Application number: 2023/93799	
What is the application for?:	Alterations to existing dwelling to create two storey dwelling with rooms in the
Address of the site or building:	7, Inglewood Avenue, Birkby, Huddersfield, HD2 2DS
Postcode:	HD2 2DS

proposed first floor

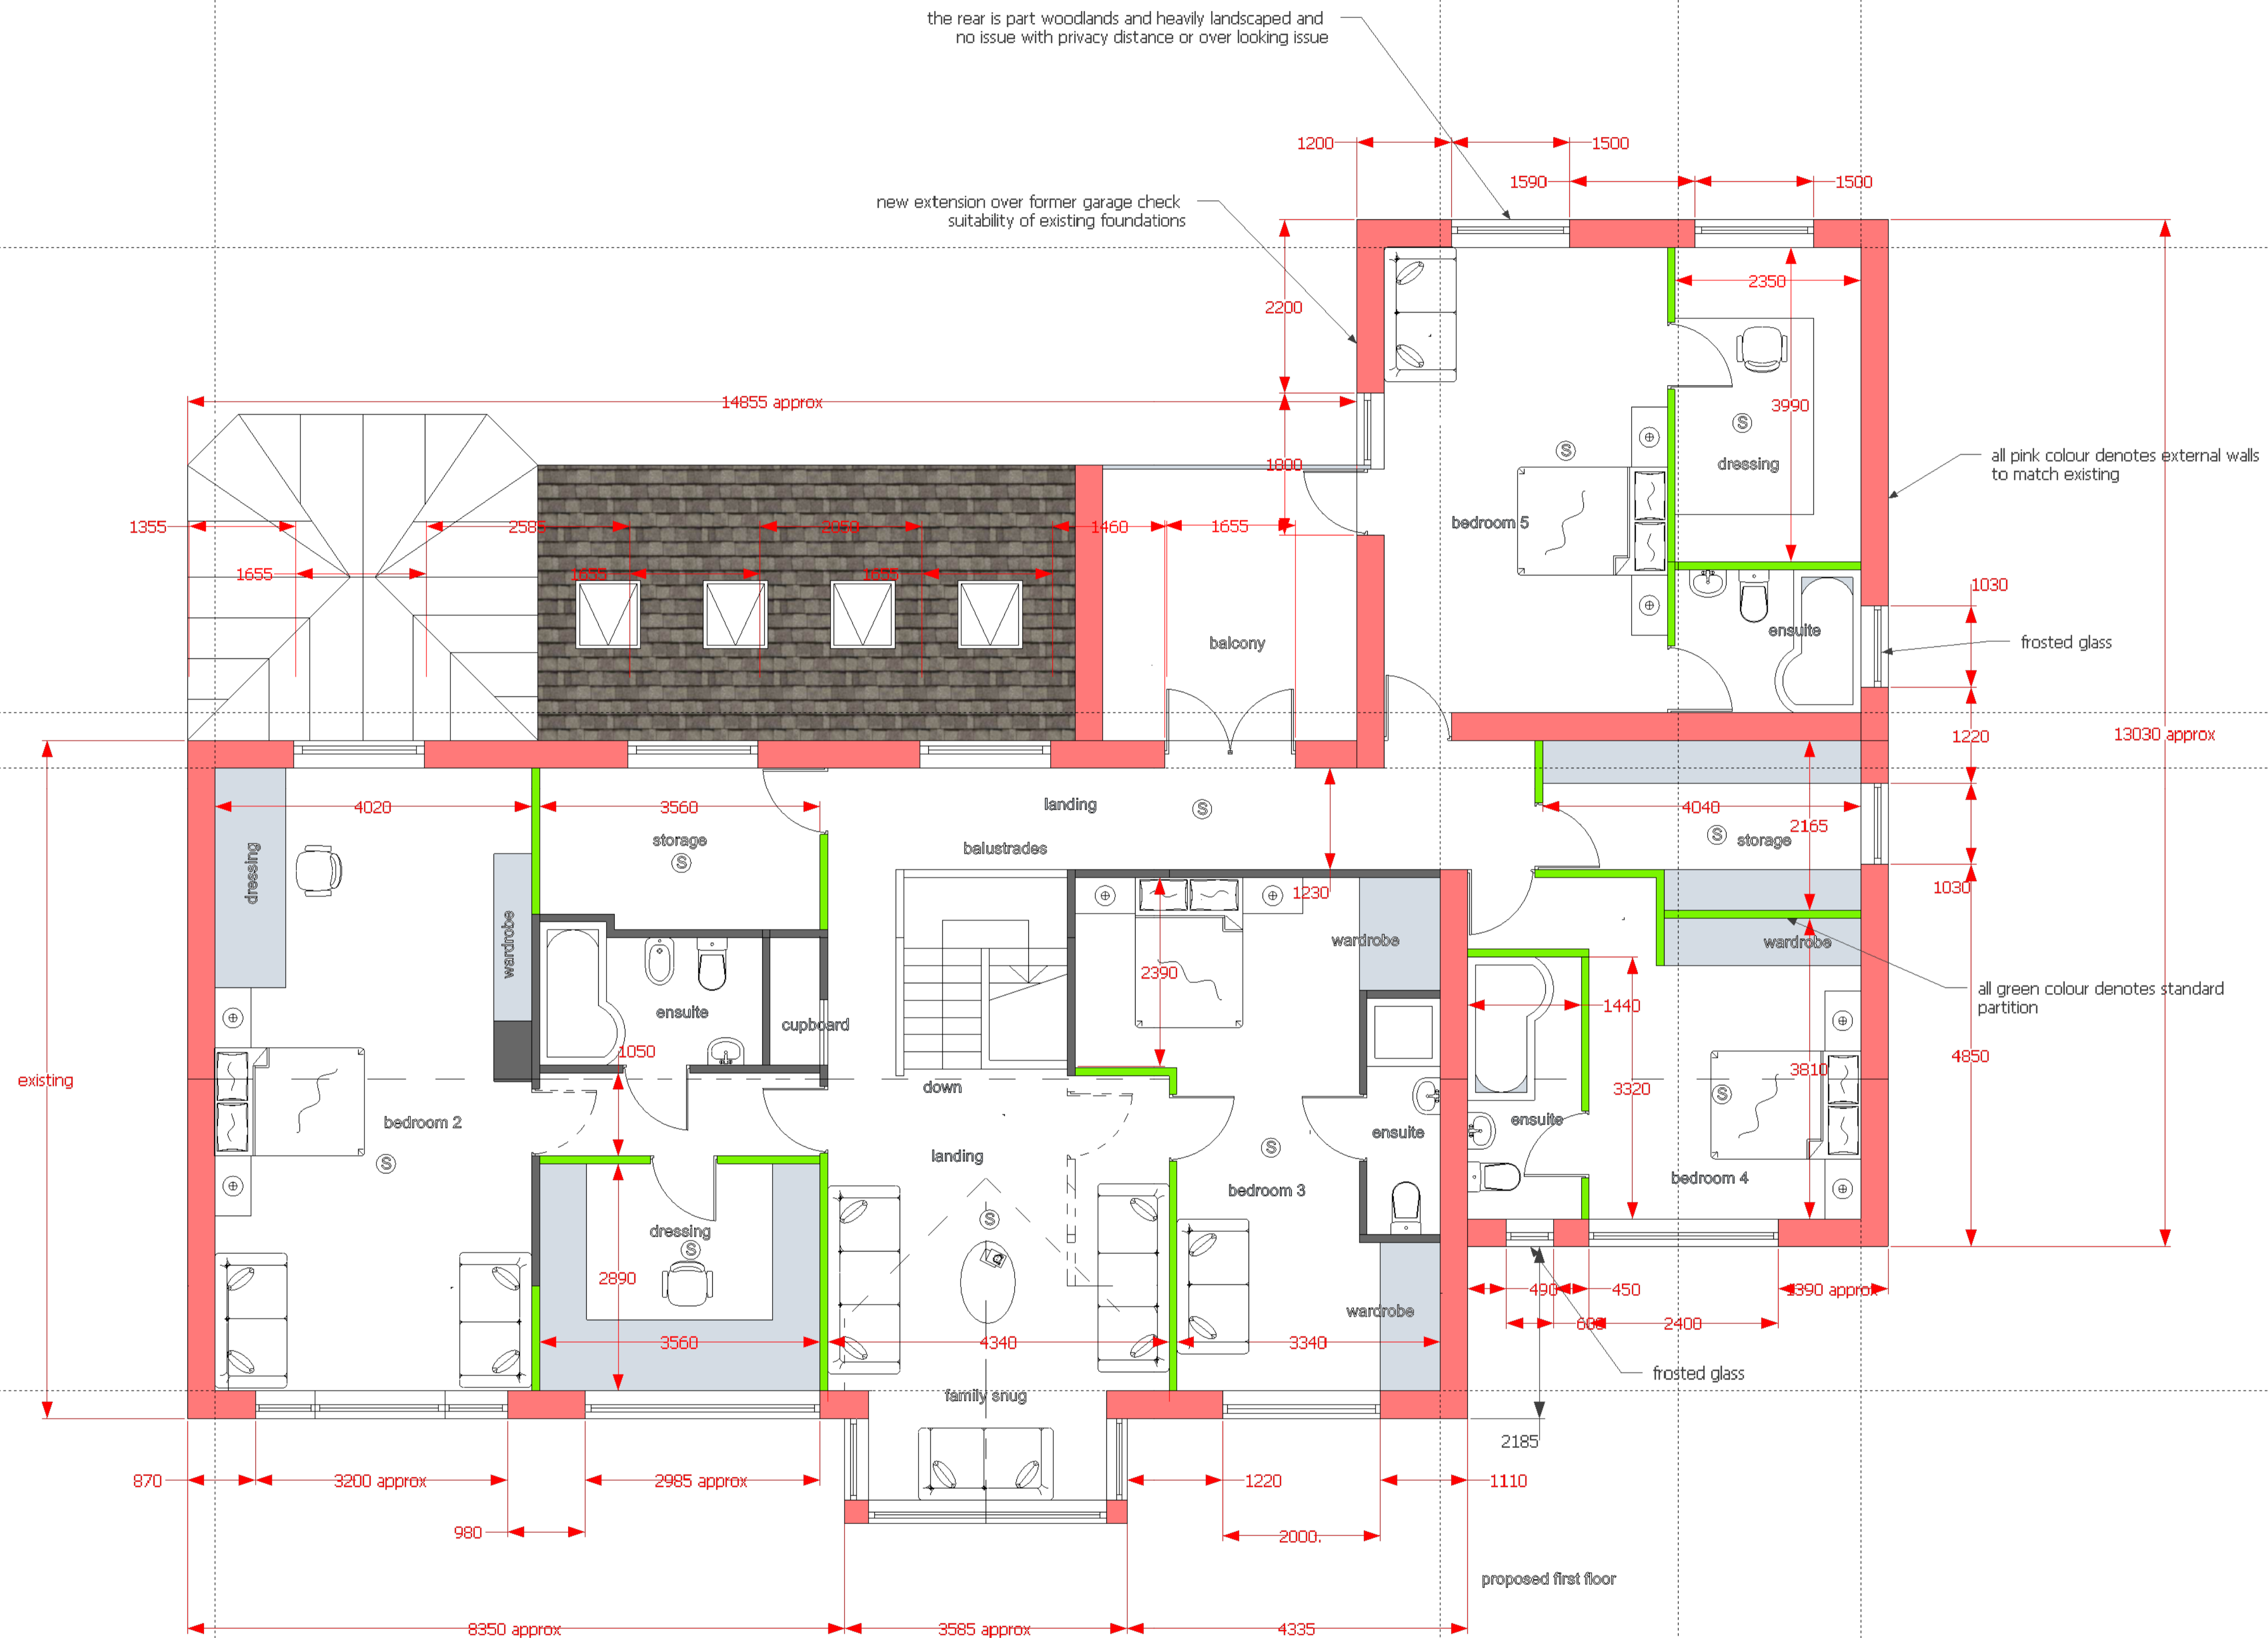
Type of comment: An objection	
Do you wish your comments to be published on the website anonymously?	Yes
Objection to the planning application. 7 Inglewood Ave. HD2 2DS The application for the extensions show building out on the west side and all the way to the boundary with number 9. This clearly will leave no space on the side of number 7. The only space left after the 2 storey build will be the side path belonging to number 9 for the side door. Number 9 gable side which is approximately 1 metre to the boundary. This will make the side on number 9 a dark corridor type space which is not found in any other house on Inglewood Ave location where number 7 or number 9 are located. Number 9 has kitchen windows and bedroom windows which now have light coming in. After the build they will be faced with a wall and windows overlooking within touching distance from bedroom window to bedroom window. There is a 2.5 metre retaining wall due to the level difference between number 7 and number 9. This wall holds up the path and the side of the entire house being number 9. There is no information on how this will be addressed. In any case we object to the retaining wall being altered in any way. This can cause movement and subsidence in number 9. Building over the garage , the garage is on the boundary and I would assume the council will demand the garage will have to be demolished. Then to be rebuilt from the foundations to support the floors above. We would have no objection to building over the original garage footprint, providing the new build is moved away a few metres from the boundary with number 9

The drawings show number 7 extending from boundary to boundary using every inch of space on the sides. Certainly not keeping to the nice spaced out homes on Inglewood Avenue.

We therefore fully object to the extensions at the west side of number 7 and next to number 9.
